City of Albuquerque Stormwater Construction Site Inspection Report

ESC File No.	U13E001	Project Name:	Tract 7 MDS		
NPDES Id. No.		Location:	9601 Broadway Blvd SE		
4/14/2022	Owner	Contractor			
Operator	MDS Investments, LLC	Guzman Construction Solutions			
Contact name & title	Kyle Bodine	Rudy Guzman			
e-mail	Kyle@sc3intl.com	rudy@guzmancs.com			
Contact Phone #	681-9932	505-459-3128			
COA Inspector	Doug Hughes	Start/End Time:	5PM		
Construction Phase:	Excavation/grading				
Type of Inspection:	<input type="checkbox"/> Regular	<input type="checkbox"/> Storm Event	<input type="checkbox"/> Past Storm Event >0.25"	<input type="checkbox"/> 311/Complaint	<input checked="" type="checkbox"/> Follow Up
Weather at time of inspection?		Cloudy	Temperature: ~		75
Estimated date of last storm 0.25" or greater		3/22/2022

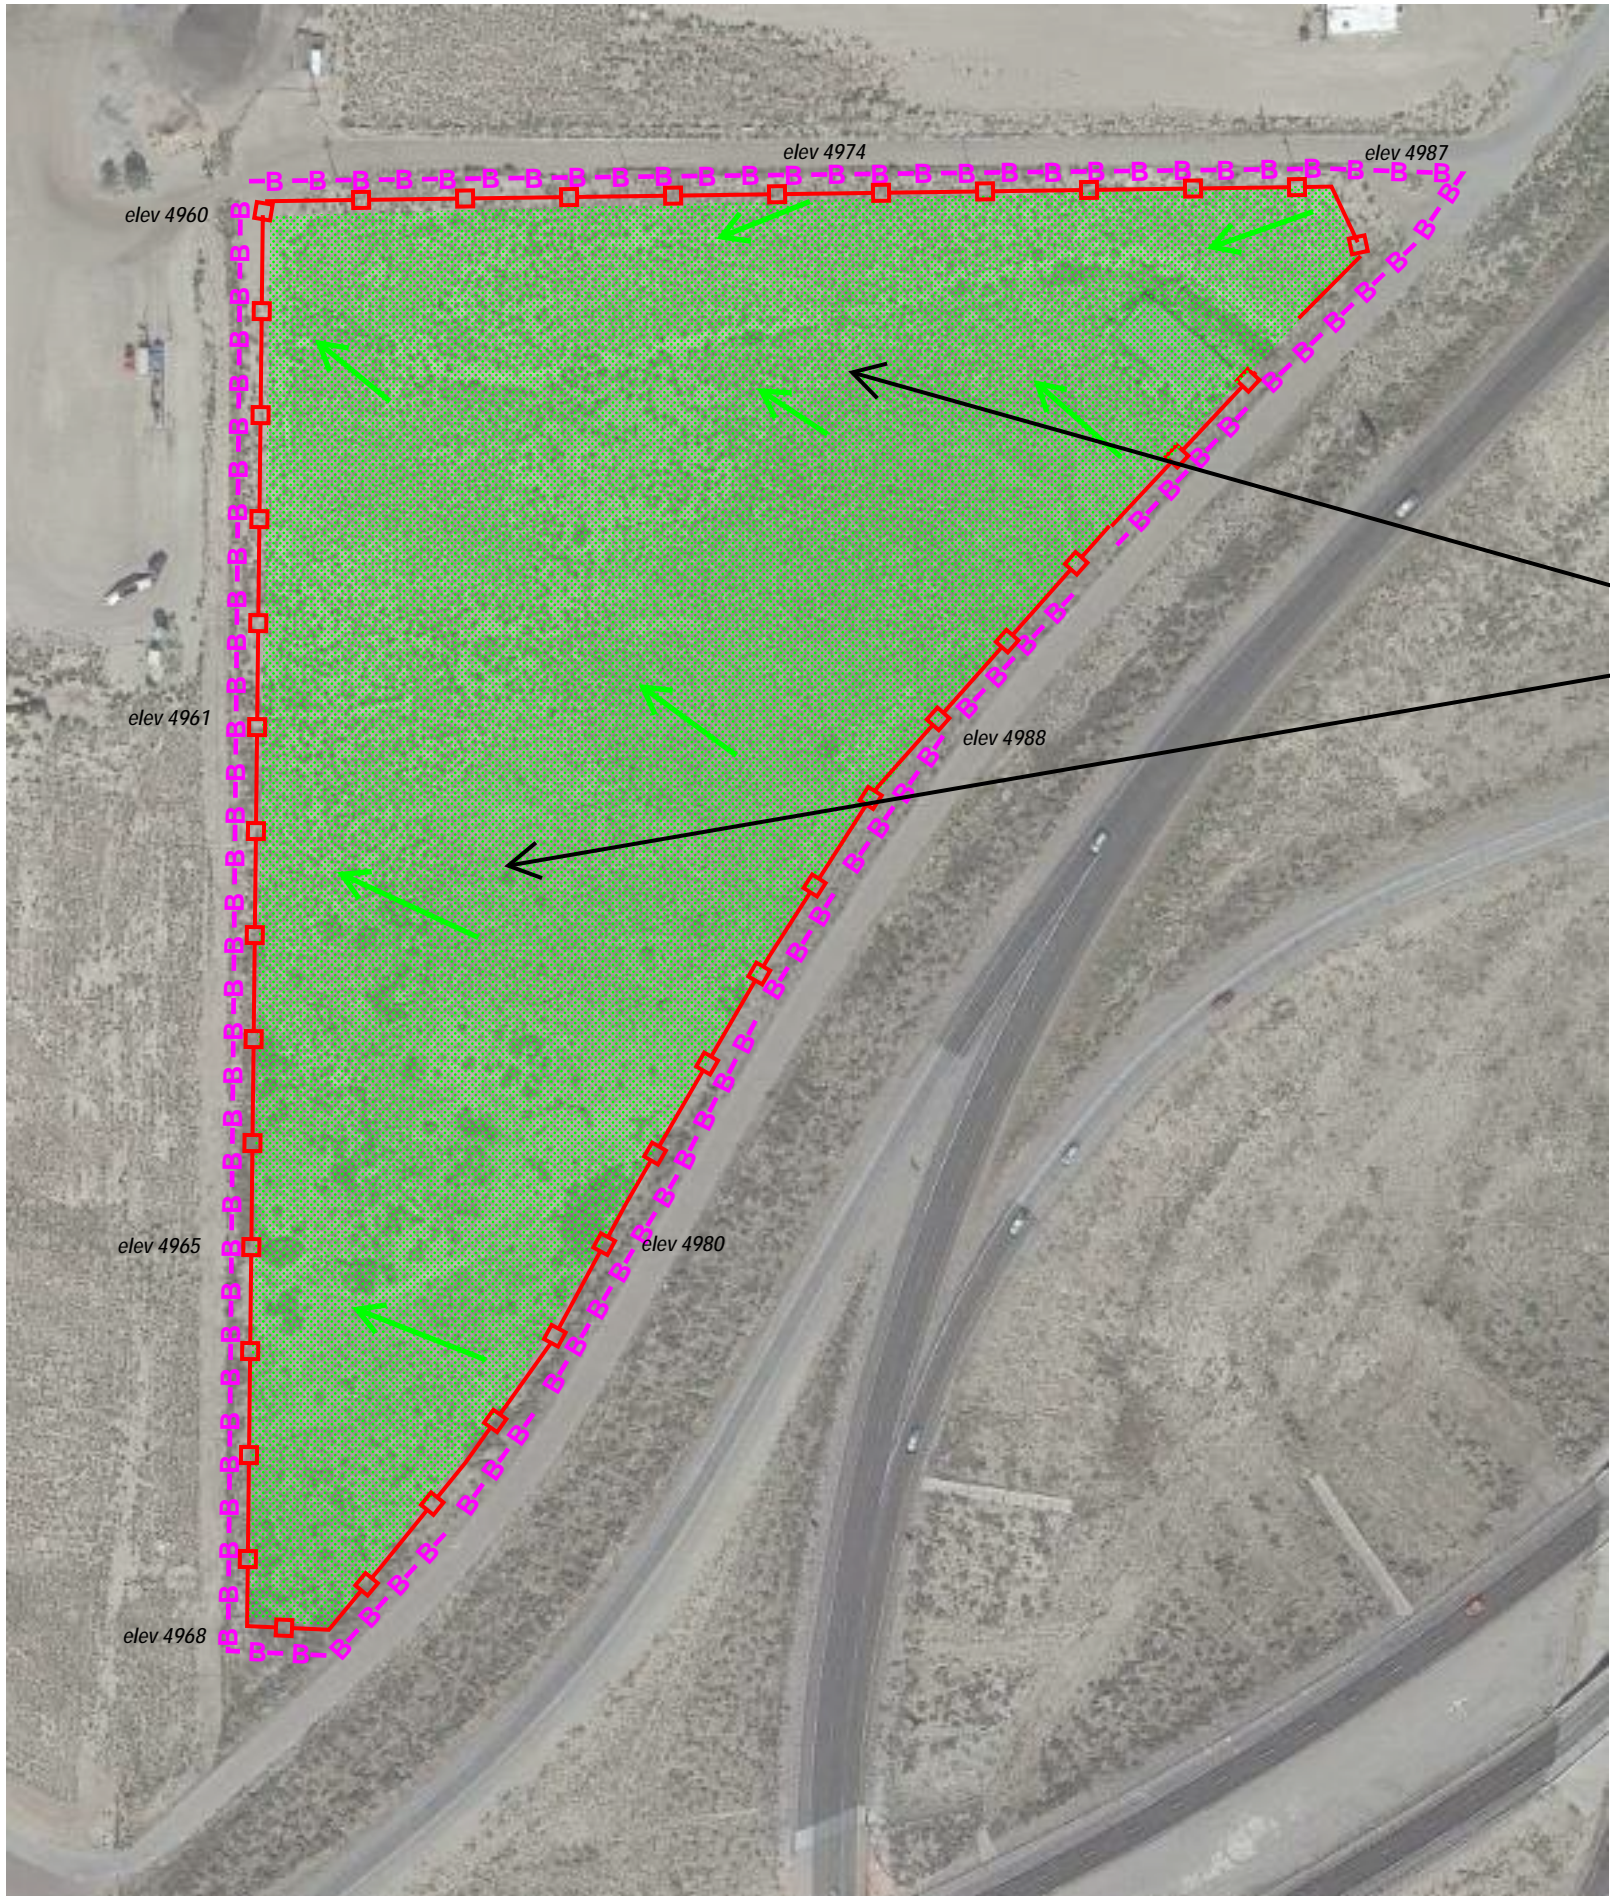
Item Number	Deficiency/ Corrective Action				
1	There hasn't been any noticeable activity in 29 days. Stabilize areas that are to remain inactive for 14 days or more per CGP2.2.14.a. The Arid and Semi-arid Exceptions don't apply this time of the year so Seed & Hydromulch would be appropriate. Alternatively Gravel is frequently used to satisfy the Final Stabilization Criteria for Construction Material Storage Yards.

The Silt Fence was in place around the perimeter though it needed maintenance in some spots
Still just 2 stockpiles.
